**Consultation Response from KC,  
Strategic Housing**

**2025/91531 land off, Leeds Road, Heckmondwike, WF16 9DB**

**Demolition of existing semi-detached houses and associated buildings, and construction of 51 dwellings, including associated access and other associated works**

**Date Responded: 20/08/2025**

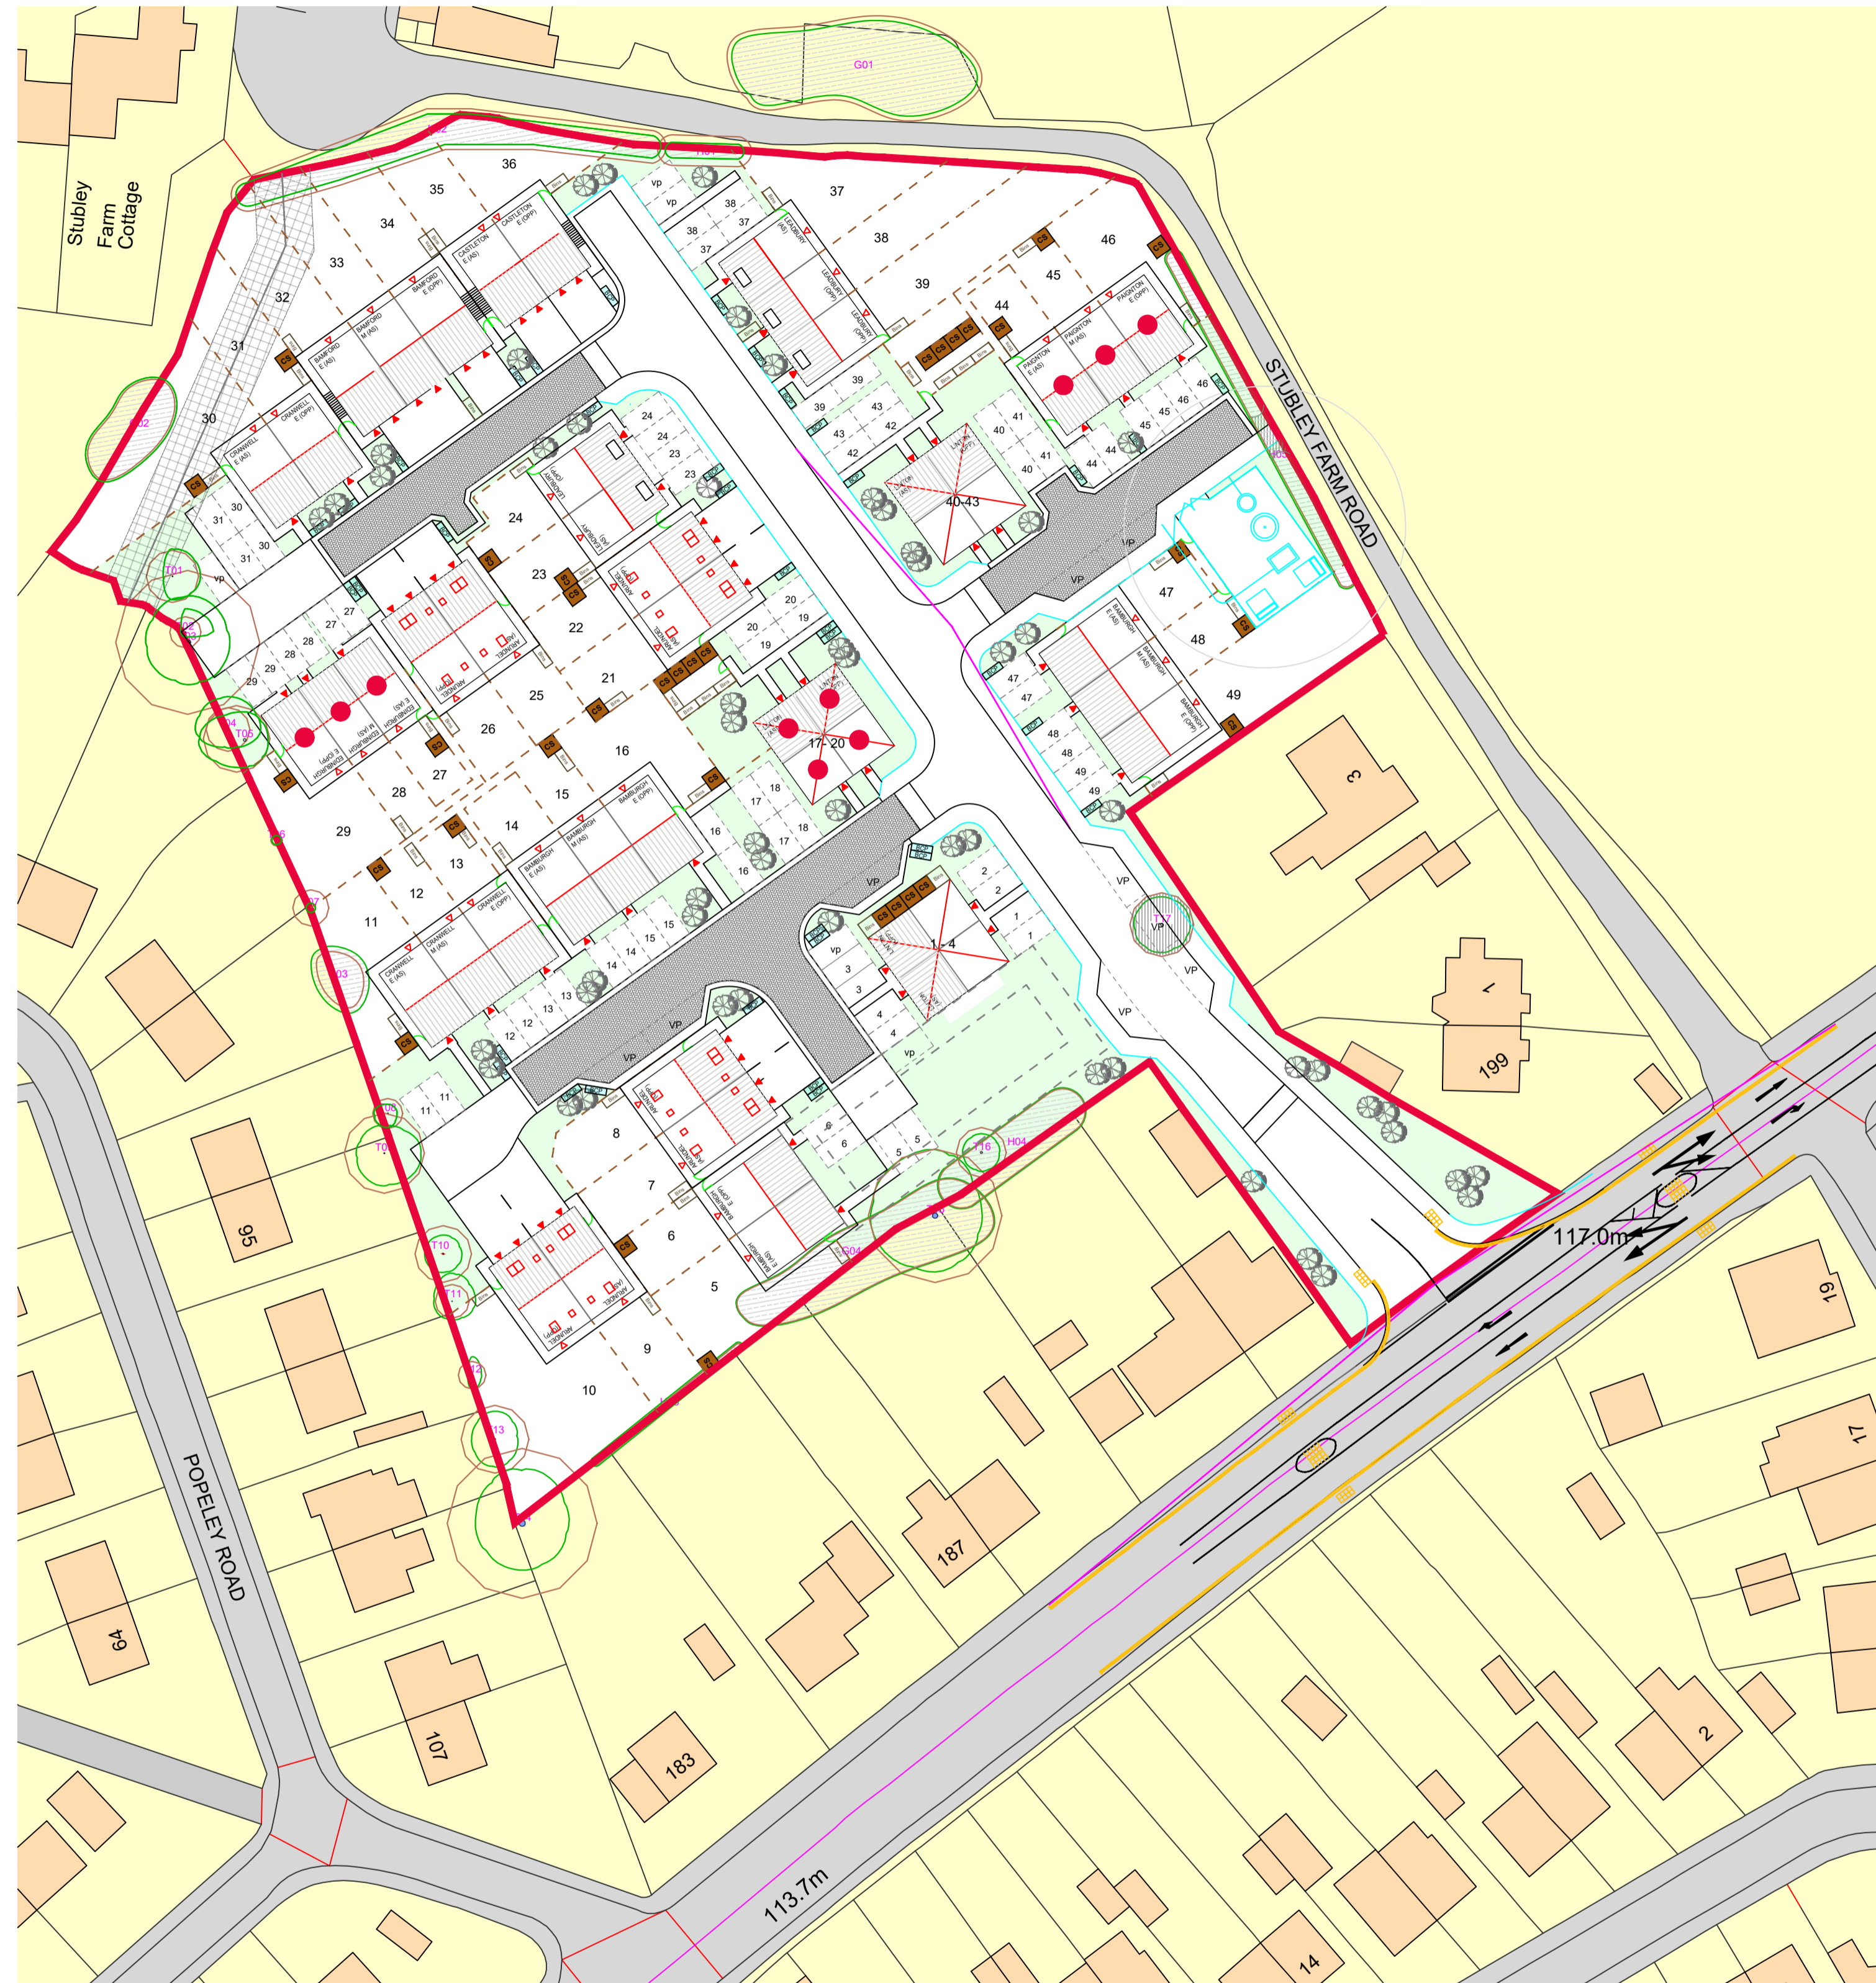
However, there is also a discrepancy regarding the stated area of the Linton house type between two plans that have been appended to the application. In the schedule of accommodation found on the Site Layout plan, the area of each Linton unit is listed as 700 sq. ft, and therefore 65 sqm. However, on the plans showing the interior of the Linton house type, the area is listed as 744 sq. ft, or 72 sqm. As a 2b3p 2-storey home must be at least 70 sqm, and an additional storey would increase the required space, the latter figure would be more likely to meet space standards.

The proposed layout shows that the affordable homes are not distributed evenly throughout the development. All proposed nine affordable units are clustered together on one side of the site, and therefore, Strategic Housing does not support the current proposal.
